**RE: Montoya Street Townhomes (File: H12D019A)
Tracts A1 and A2 Lands of David Maciel
Montoya St NW between Floral Rd and I-40
Grading Plan and Drainage Report
Engineer's Stamp Date – 12/16/2015**

RE: **Montoya Street Townhomes (File: H12D019A)**
Tracts A1 and A2 Lands of David Maciel
Montoya St NW between Floral Rd and I-40
Grading Plan and Drainage Report
Engineer's Stamp Date – 10/15/15

REVISED
DRAINAGE REPORT

ENGINEER'S SEAL  10/15/15 DAVID SOULE P.E. #14522	MONTOKA STREET TOWNHOMES	DRAWN BY WCUJ
	GRADING AND DRAINAGE PLAN	DATE 10-15-15
		21523-LAYOUT-8-05-15
 Rio Grande Engineering 1806 CENTRAL AVENUE SE SUITE 201 ALBUQUERQUE, NM 87106 (505) 872-0999	SHEET # —	JOB # 21523

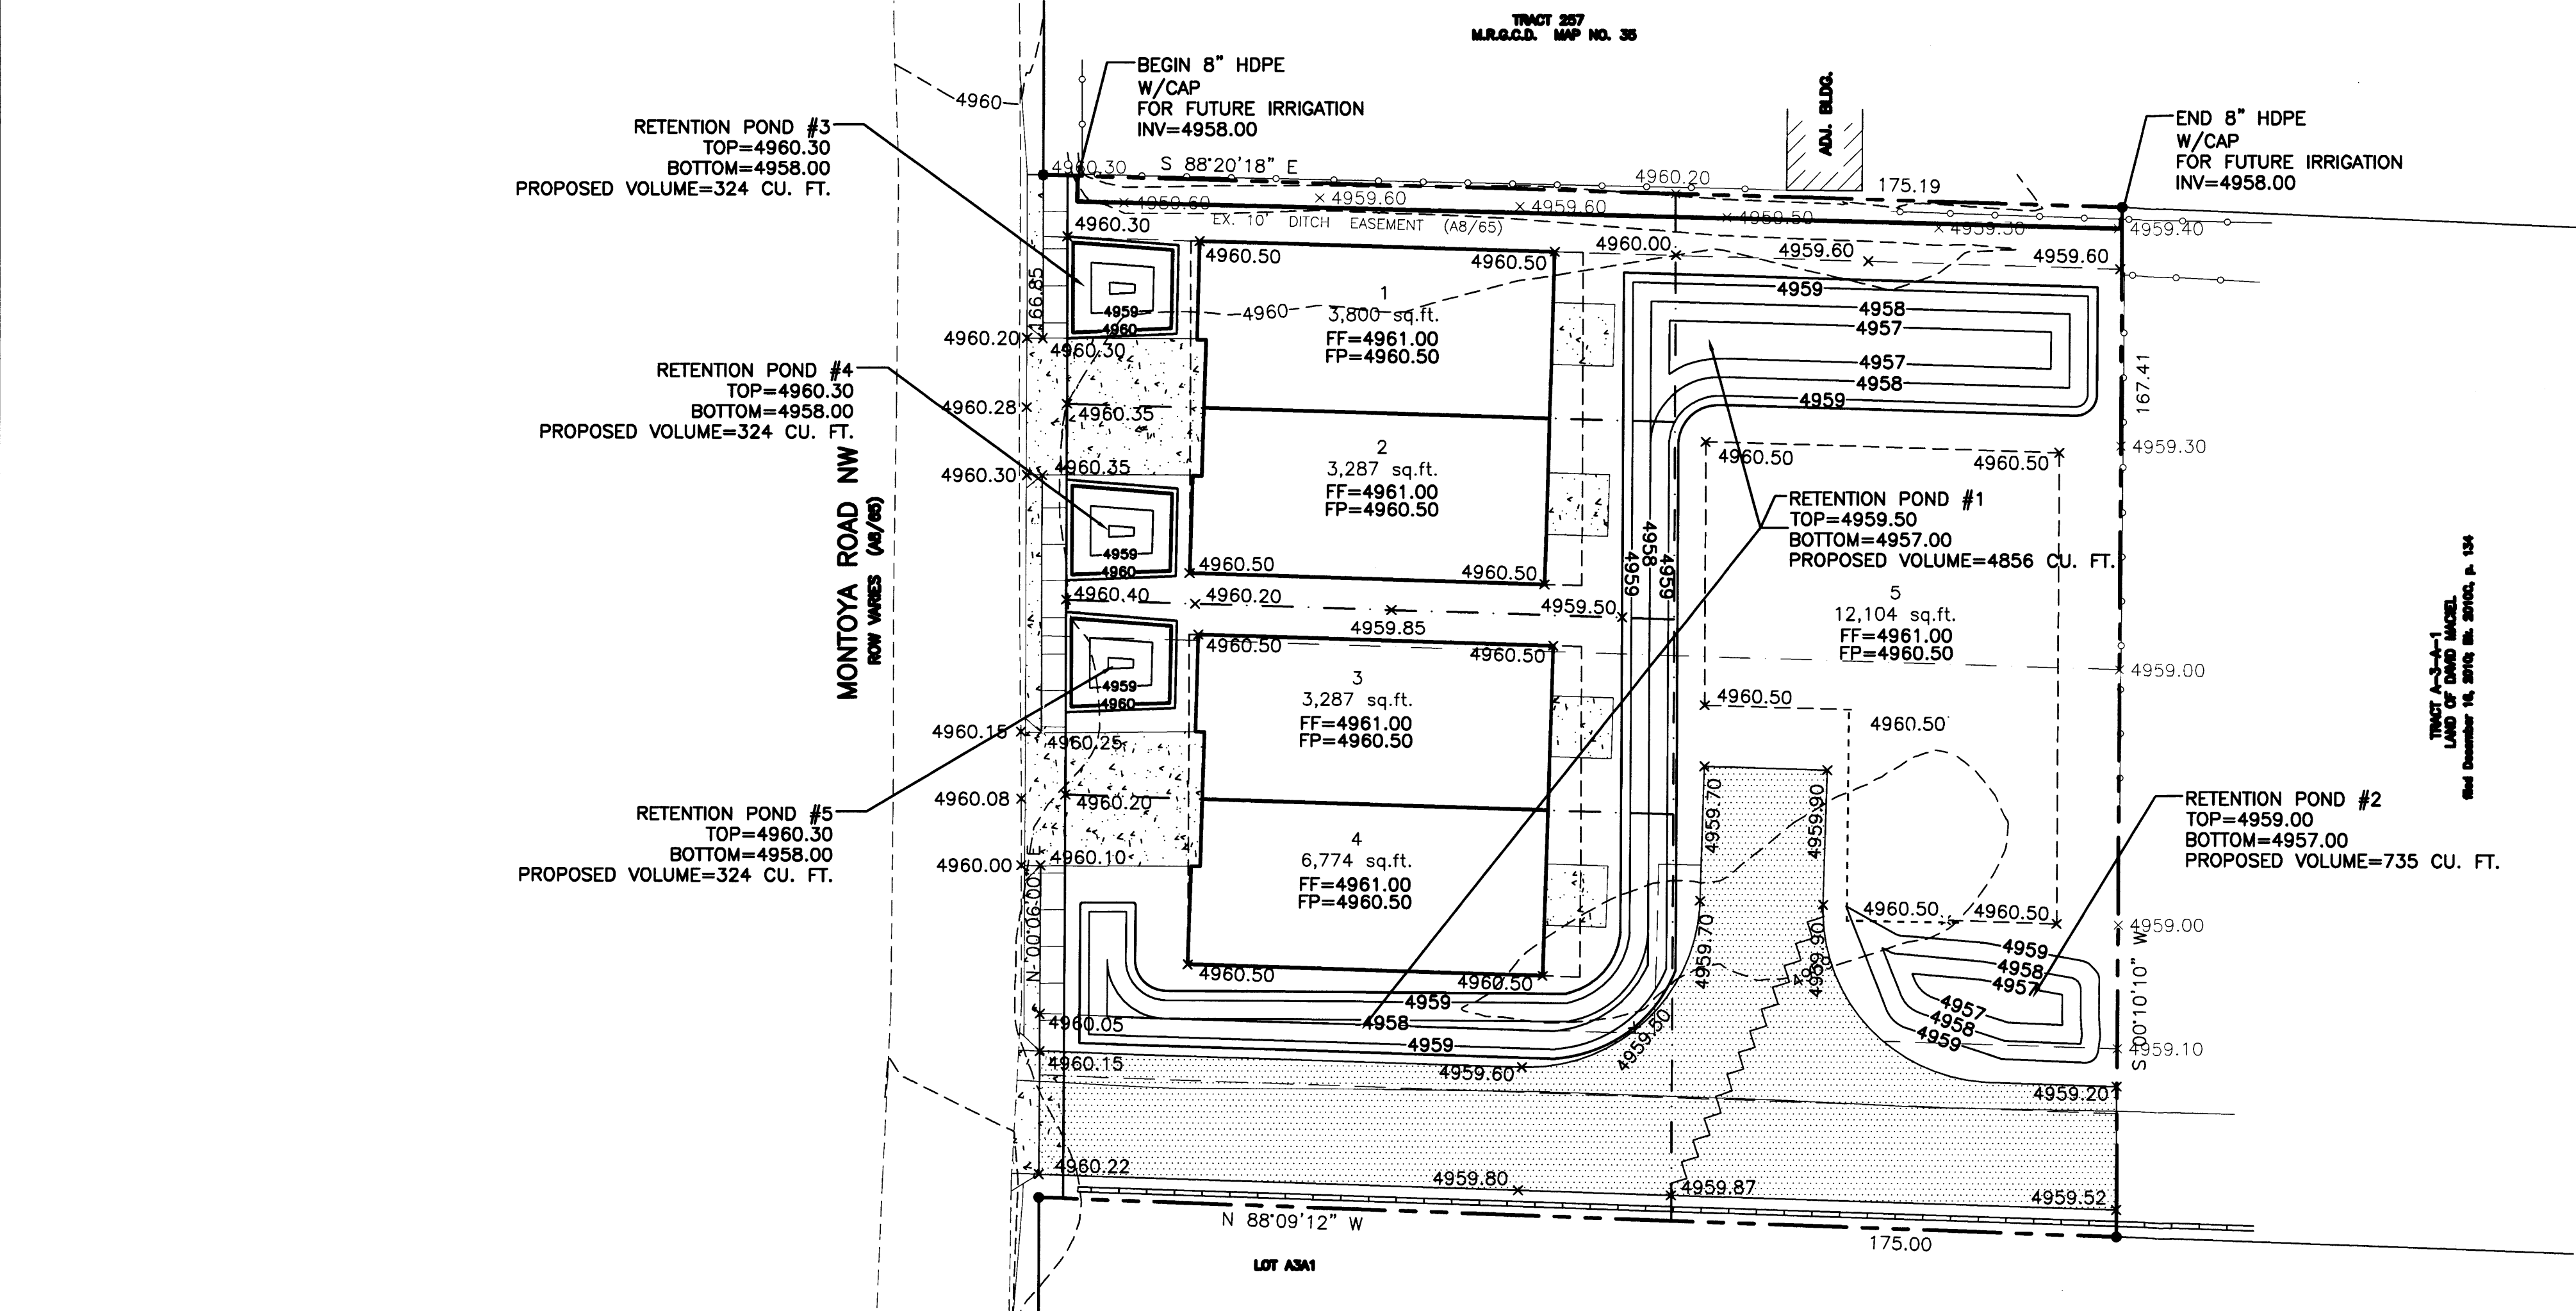
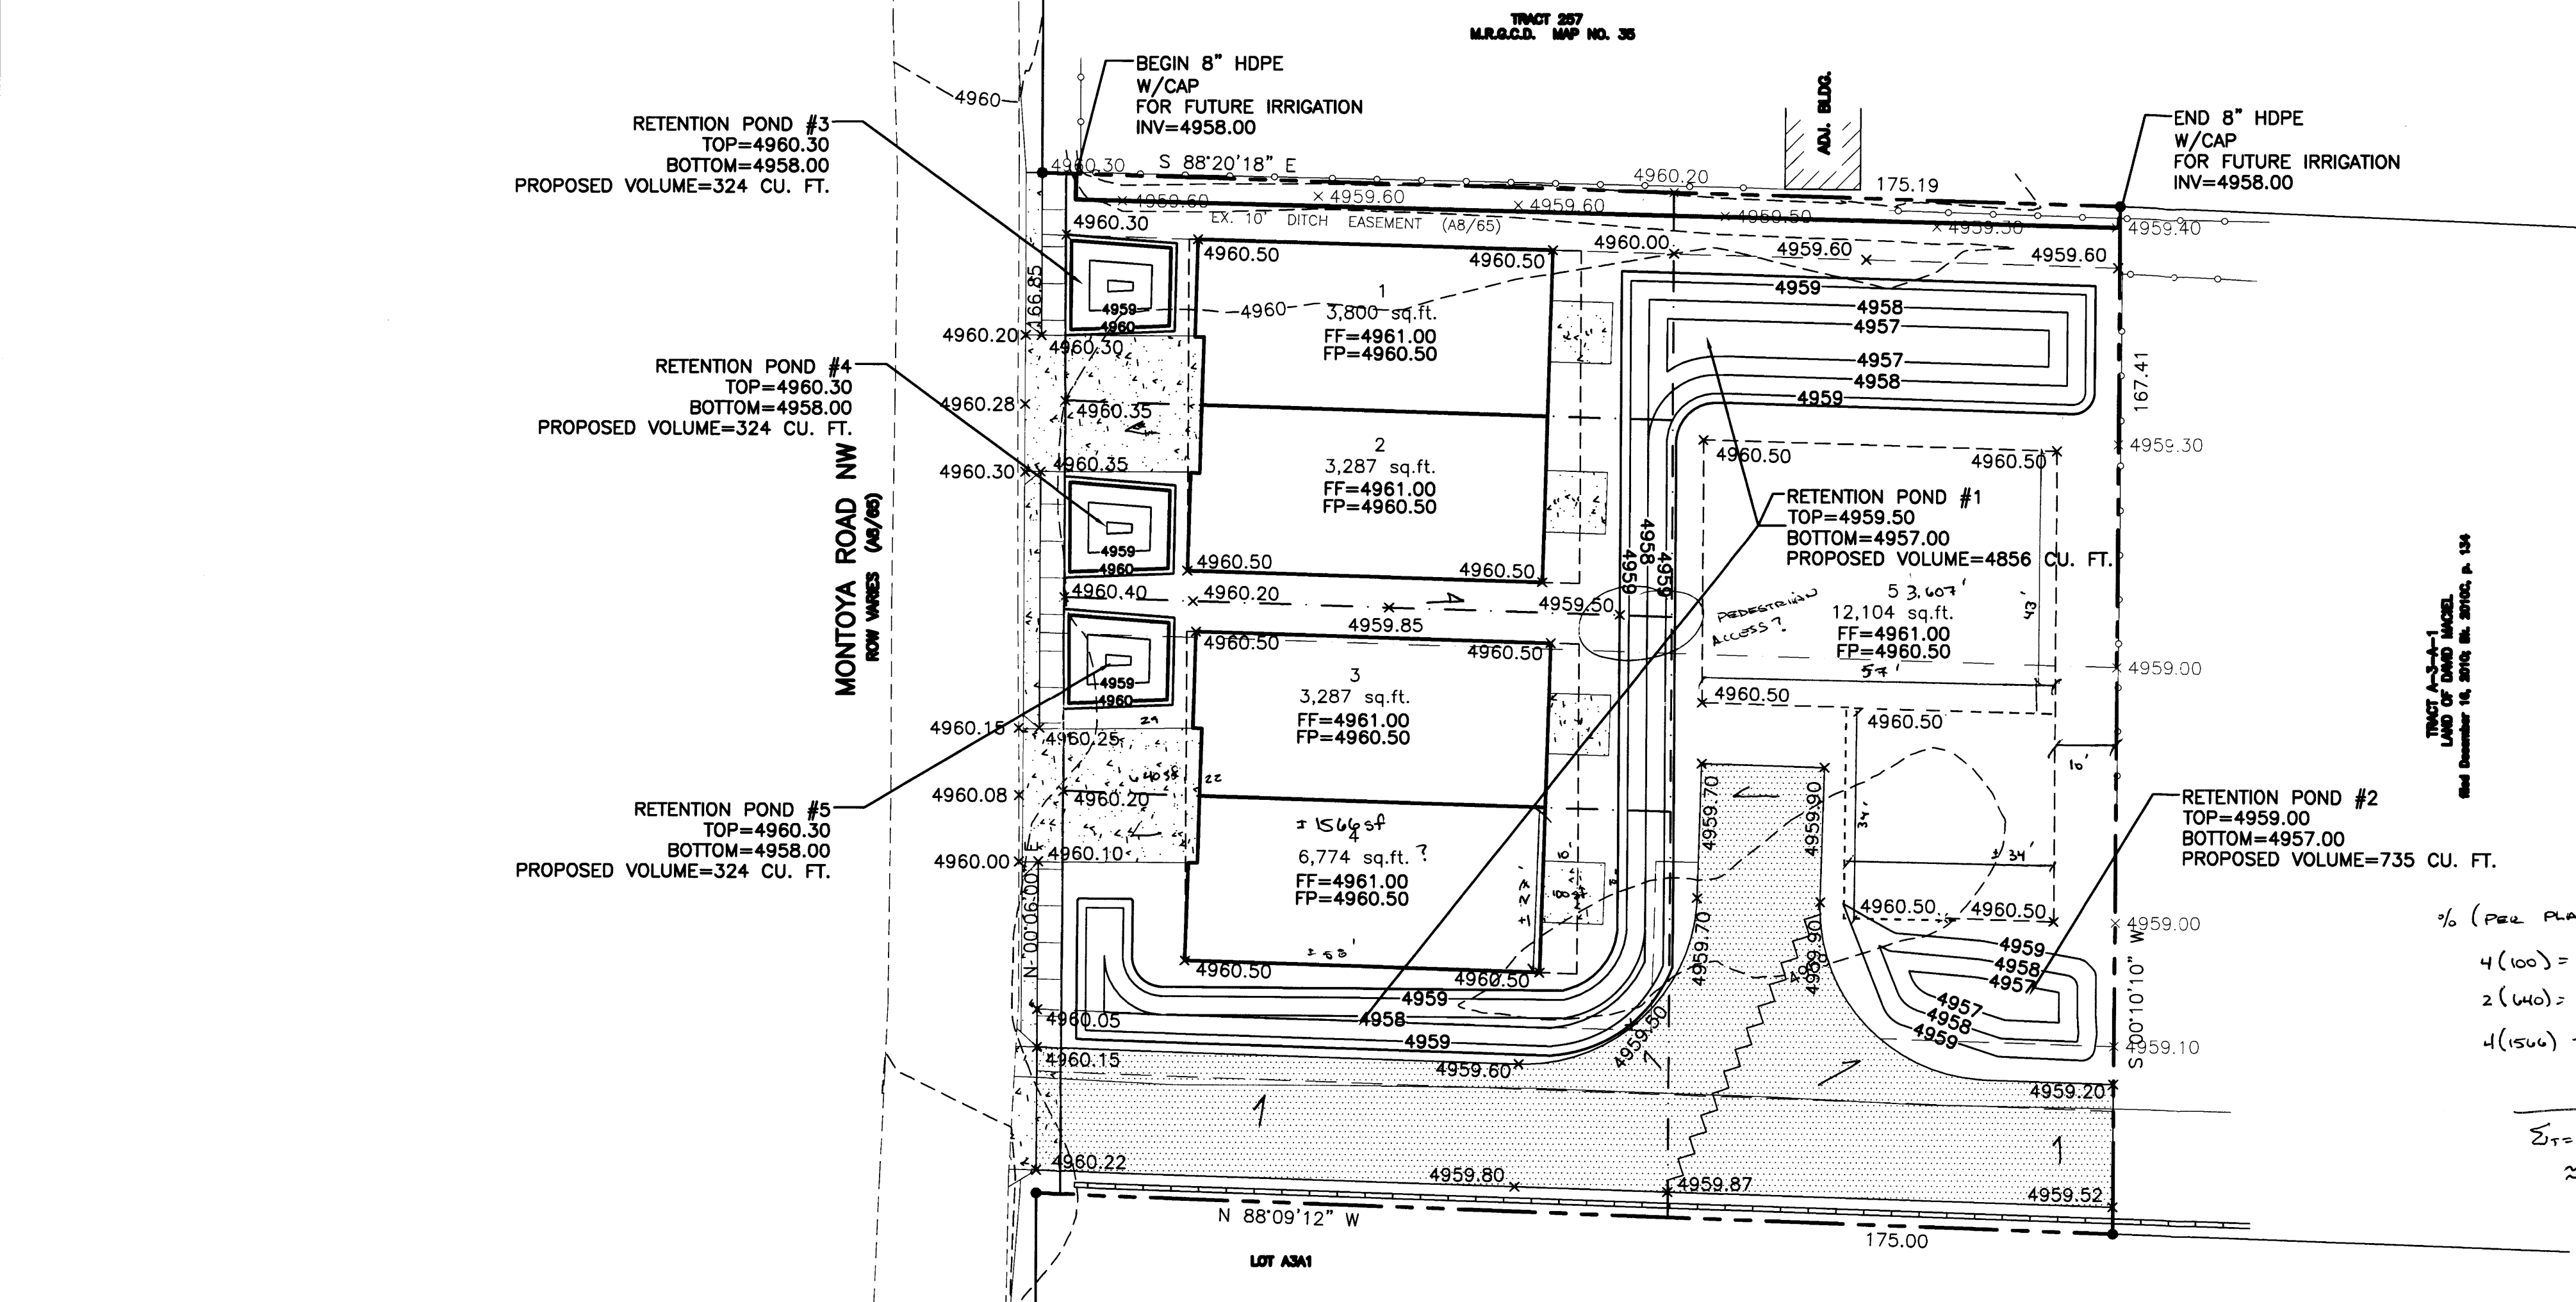
- Provide drainage flow areas to better identify overall site drainage patterns. **ADDED BASIN MAP**
- Provide roof flow direction and outfall locations. **ADDED TO PLAN**

- Clearly identify and define property lines. **"**
- Clearly identify the location and limits of the 10 ft Ditch Easement located on the north property line. **"**

- The Drainage Report indicates flows from a storm event exceeding the 100-yr, 6 hr storm event will discharge to Montoya Street. Per the spot elevations identified on the Grading Plan, it appears flows will be directed east away from Montoya Street. Show on the Grading Plan how this will be achieved. **REVISED REPORT TO CORRECT**

- The Drainage Report states the platting action will allow for cross lot drainage easement on all parcels yet the Drainage Report identifies flows to be retained onsite or discharged onto Montoya Street during a larger design storm. Provide offsite flow information and how offsite flows will be managed onsite. **ADDED BASIN MAP**

- A scale check on the area for townhomes 1-5 appears as though the area provided is incorrect. Re-check the areas to ensure the information is correct. **CORRECTED**
